Engineers Comments Regarding Surface Water Drainage

Application Reference:	AL/13/25/DOC	Reviewer Reference:	ADC/EXT2/D2134/70
Planning Officer:	Hannah Kersley	Date of Review:	12.09.2025
Site Name:	Karenza Hook Lane Aldingbourne PO20 3TB		
Application Description:	Approval of details reserved by condition imposed under reference AL/154/23/PL (APP/C3810/W/23/3335883) relating to condition number 3 - Construction Management Plan, condition number 5 - surface water drainage scheme, condition number 8 - external materials and finishes and condition number 9 - energy.		
Assessment Number:	2 of 2

Application Reference: AL/13/25/DOC Site Name: Karenza Hook Lane Aldingbourne PO20 3TB	Initial Issue Date: 29.04.2025 Issue Date: 12.09.2025 Reviewer Reference: ADC/EXT2/D2134/70
---	---

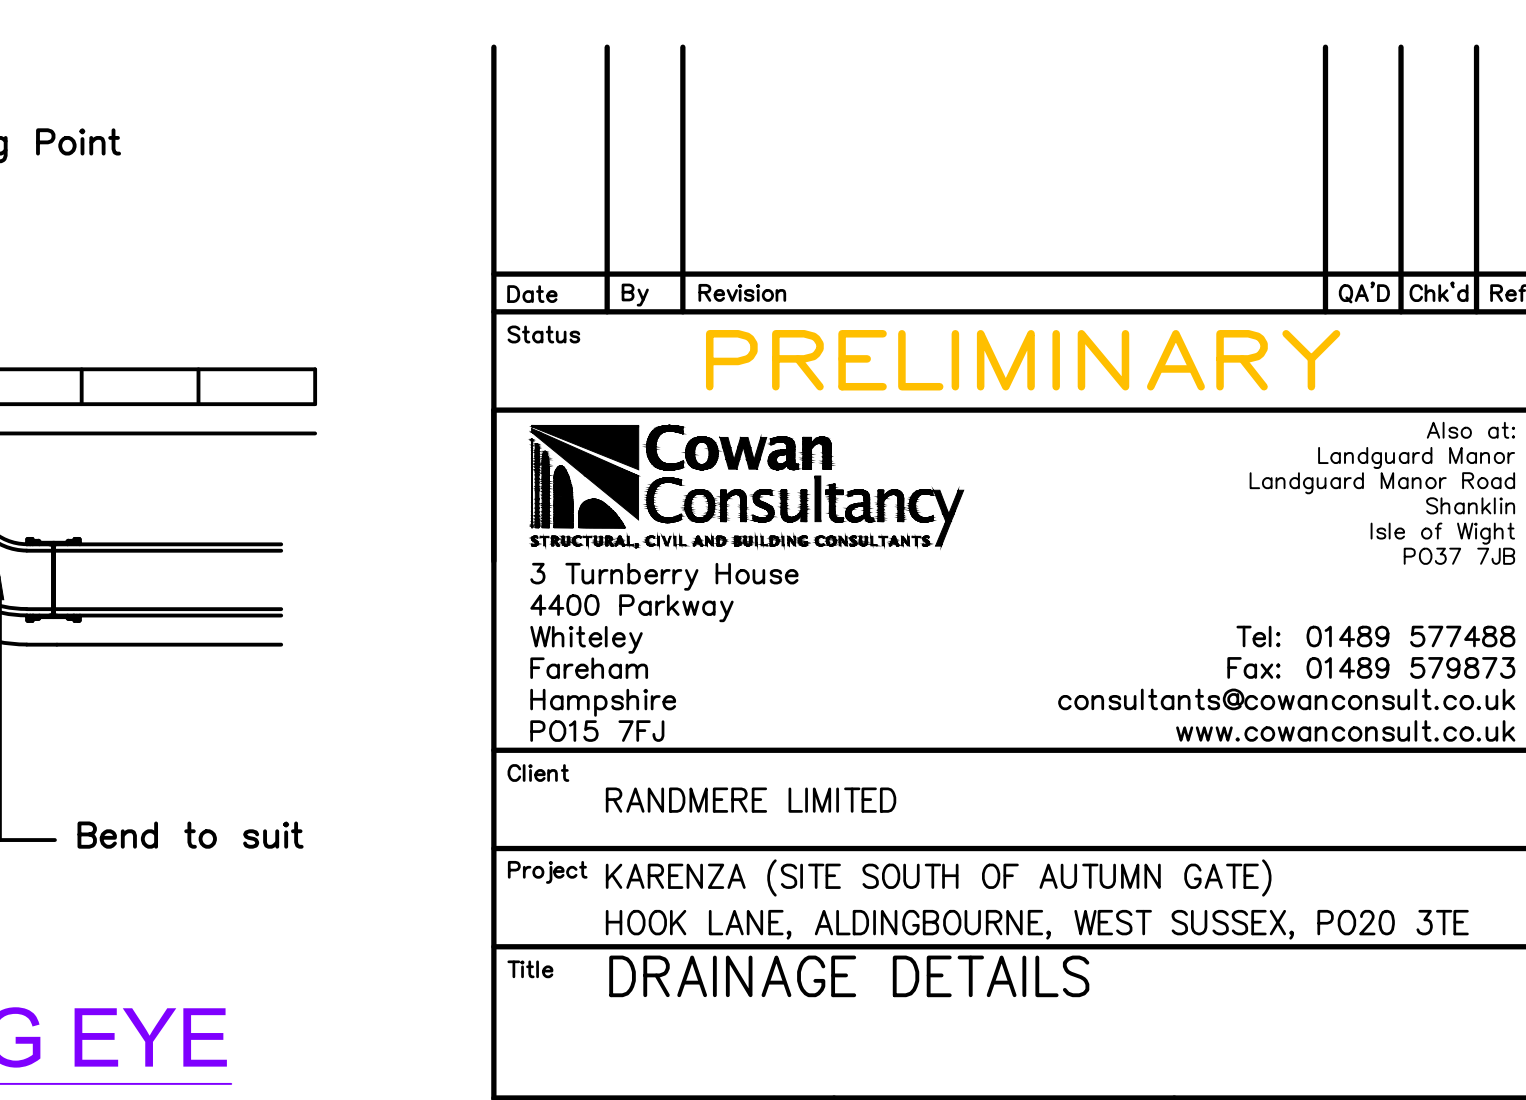
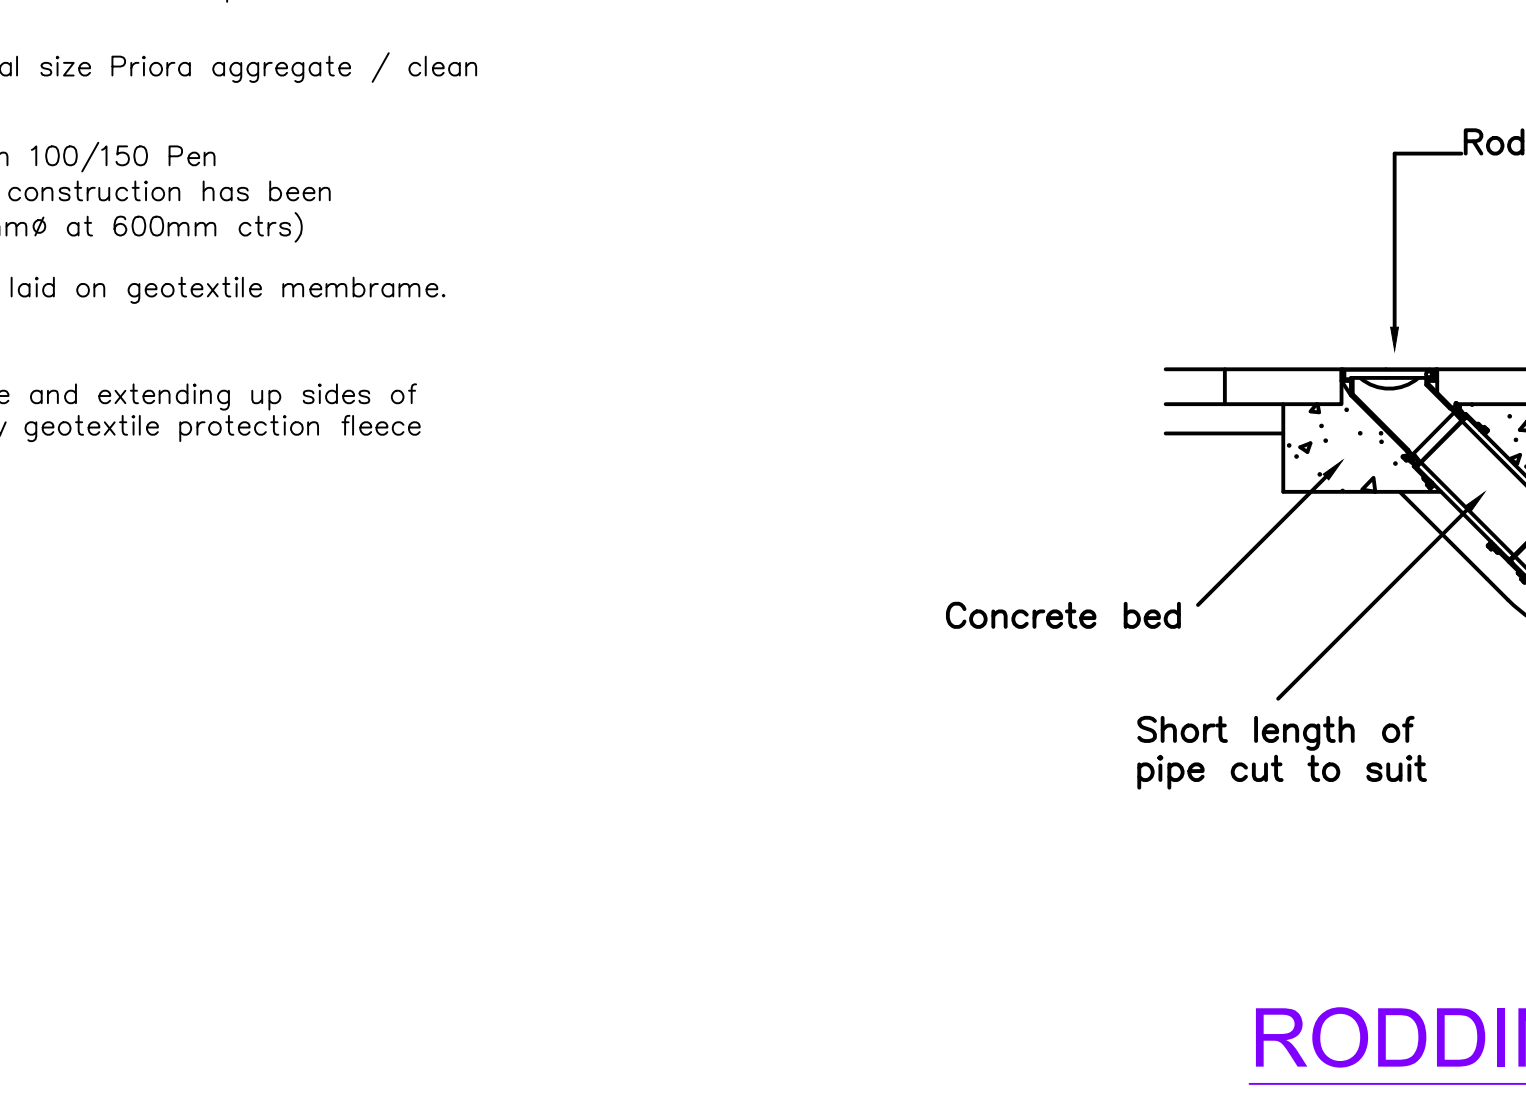
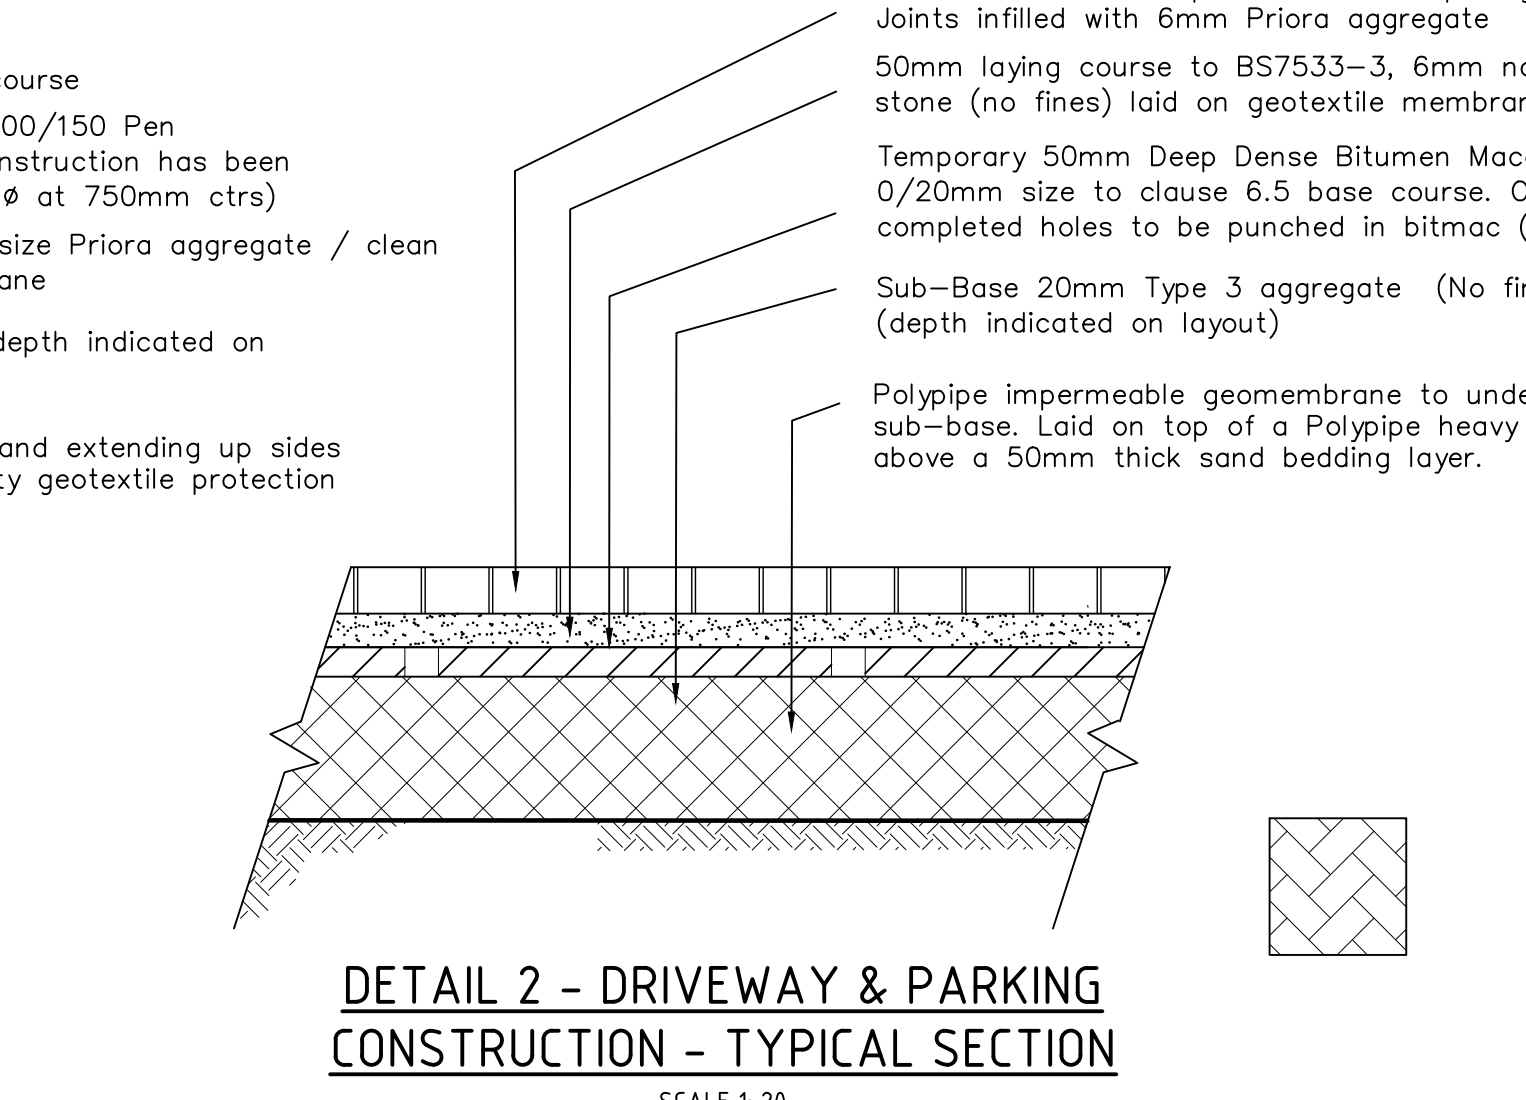
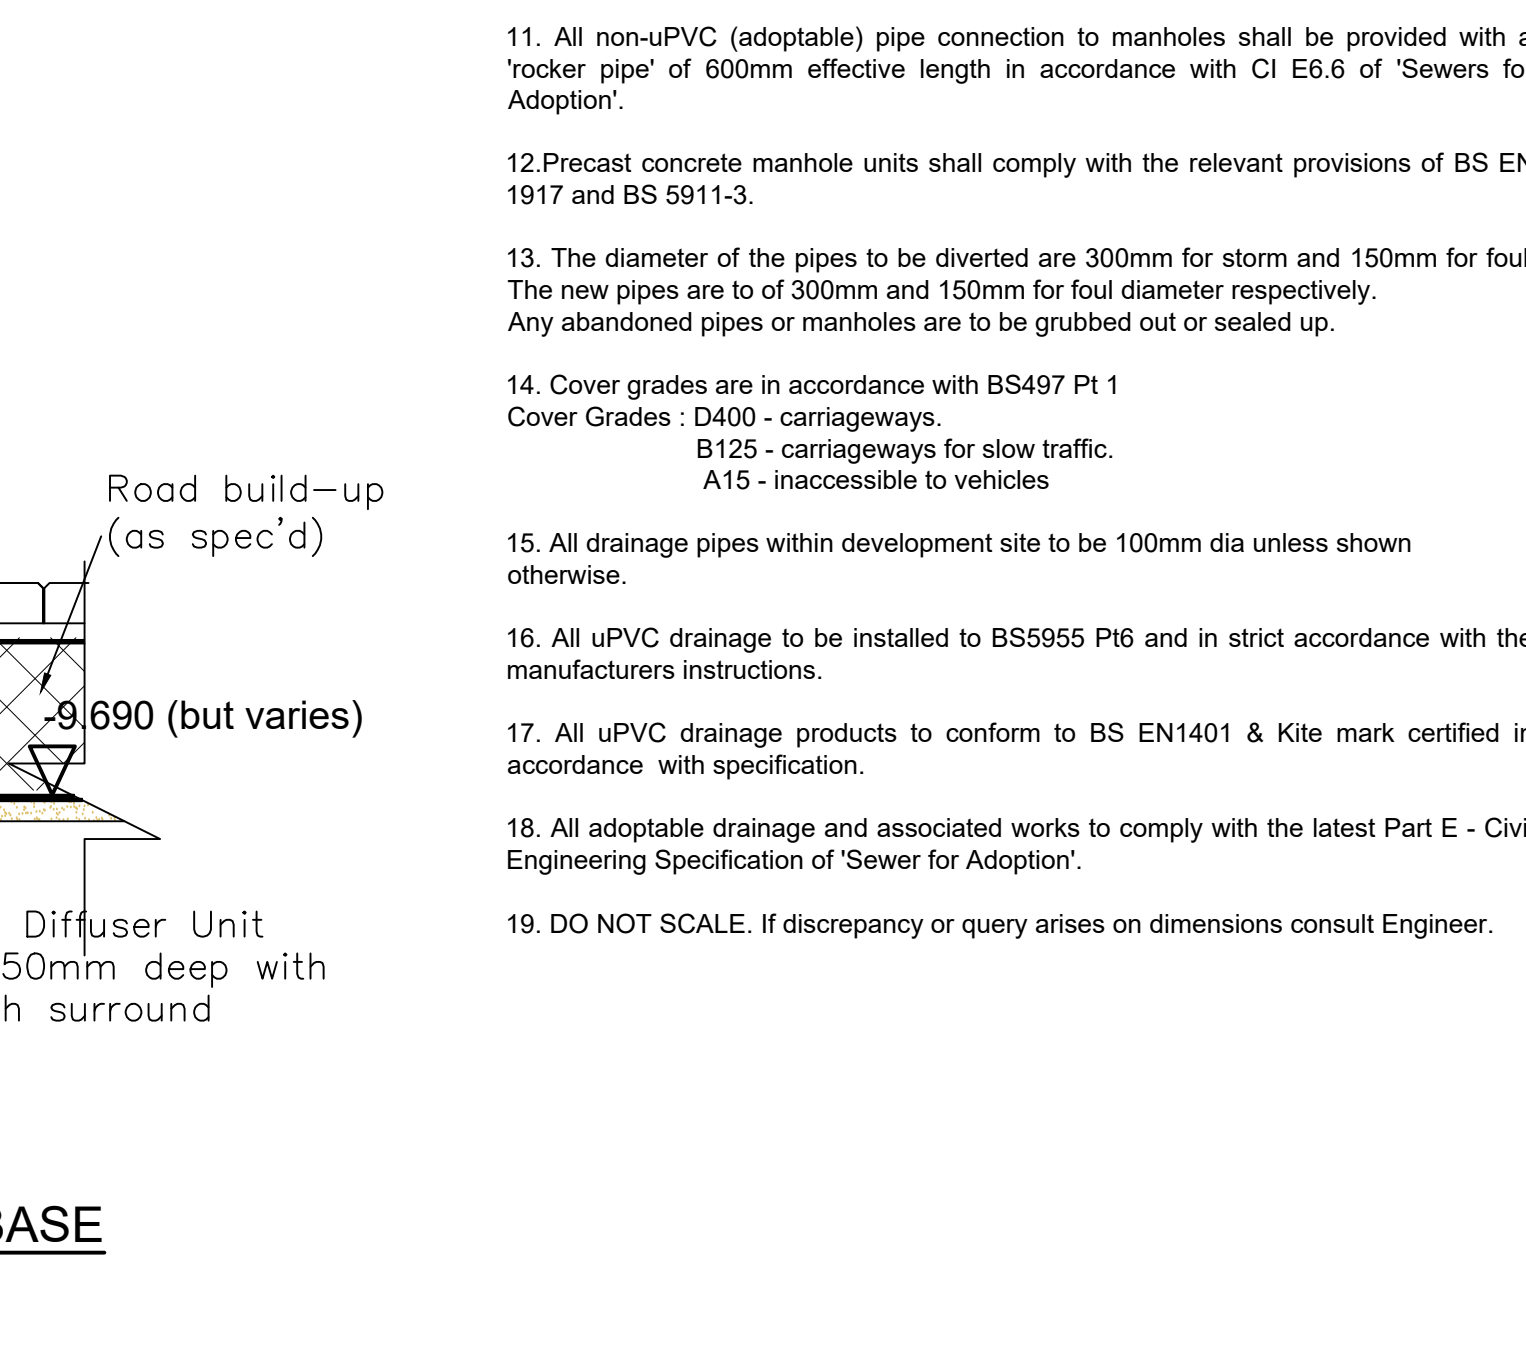
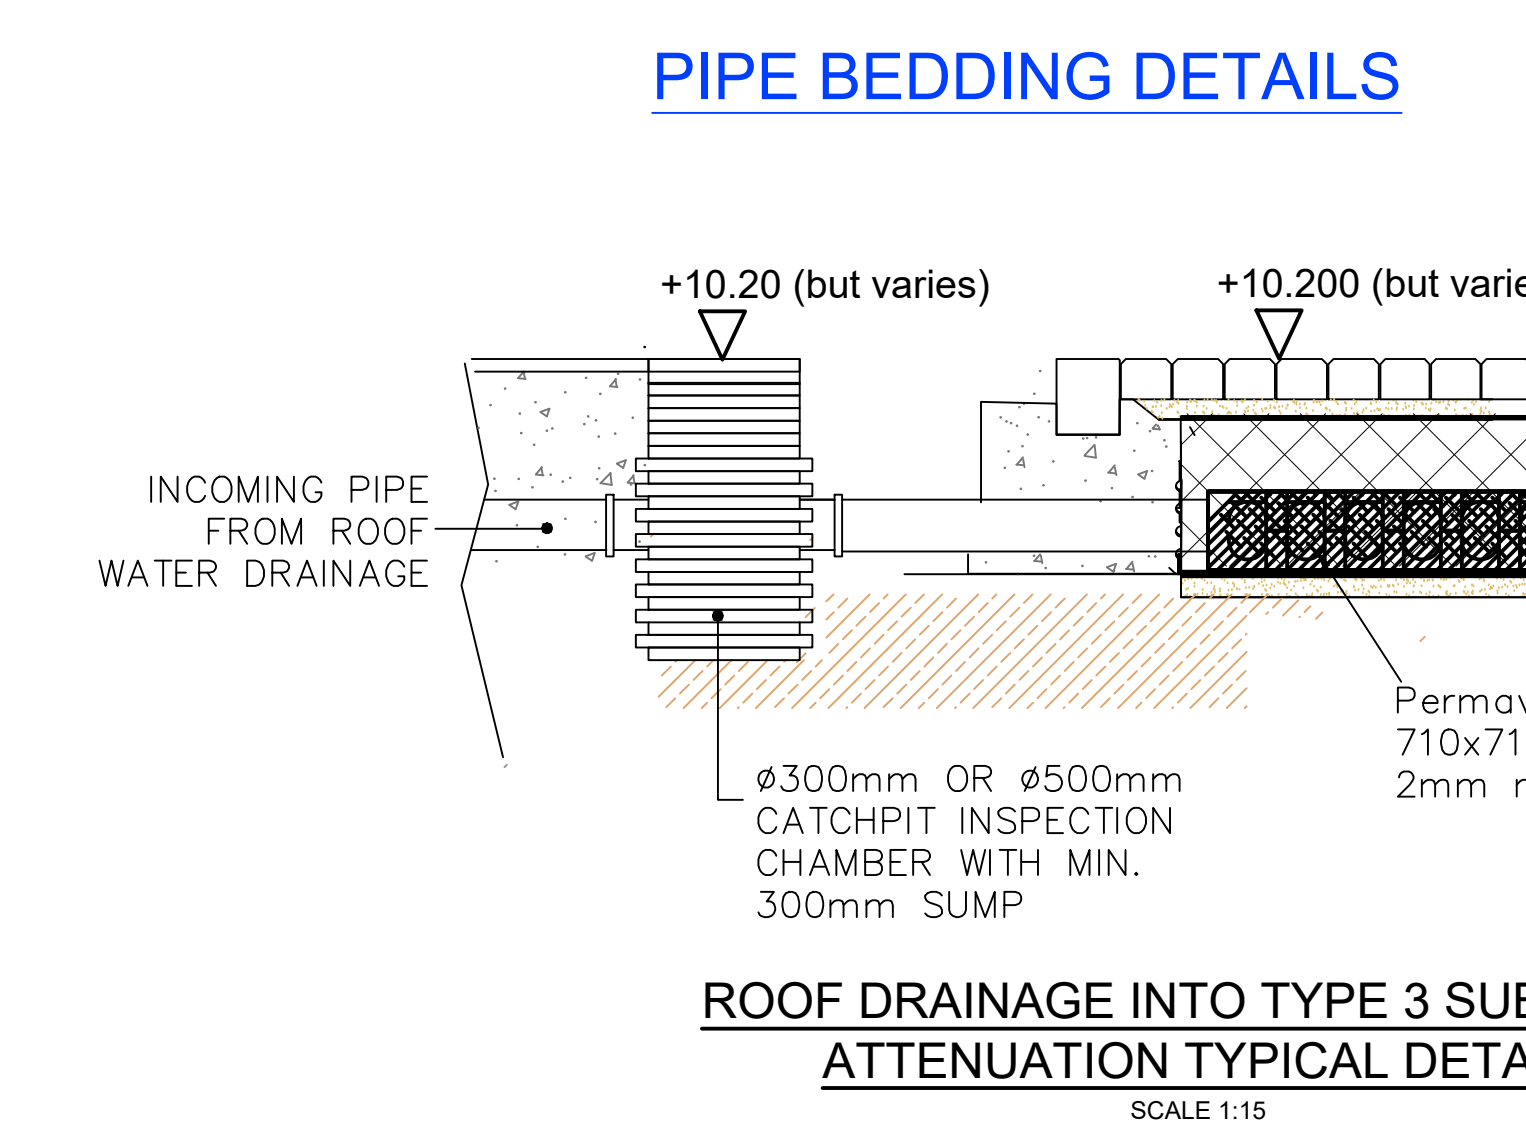
14.	The hydraulic calculations specify node SW-13 as a vortex flow control with an invert of 9.49m, however drawing 435050-221P2 shows this to be higher @ 9.494m. As cited above, for certainty the as-built levels must be used as they may not correlate with the phase 1 design.	Amended in the model	To clarify this is now SW-14 in the revised calcs with the correct invert. Comment closed.

20.	Drawing 435050-221P2 is very difficult to review where phase 1 is greyed out and the key does not clarify all items i.e. its is assumed the pink text represents the phase 1 formation levels?	The revised drawing is clearer and also the construction issue of phase 1 has now been provided	Comment closed.

21.	Drawing 435050-221P2 requires formation levels at all corners and at	This has been added	Comment closed.

25.	Please provide details of the foul drainage routing so this can be reviewed in conjunction with the surface water drainage.	Foul added on layout	Still missing on drainage GA drawing 221P. Comment outstanding.

26.	Please provide details of the main service routing/crossings so this can be reviewed in conjunction with the surface water drainage.	Service routings added on layout	Still missing on drainage GA drawing 221P. Comment outstanding.

30.	Drawing 435050-221P2 is very light on spot levels, no contours it is not possible to deduce where exceedance run-off will travel.	Exceedence flow layout provided in Appendix E	Comment closed.

35.			S12 orifice is noted as 35mm on the drainage GA drawing 221P and 45mm in the 1D model. Please advise the correct value, noting the National Standards recommendations for block risks.
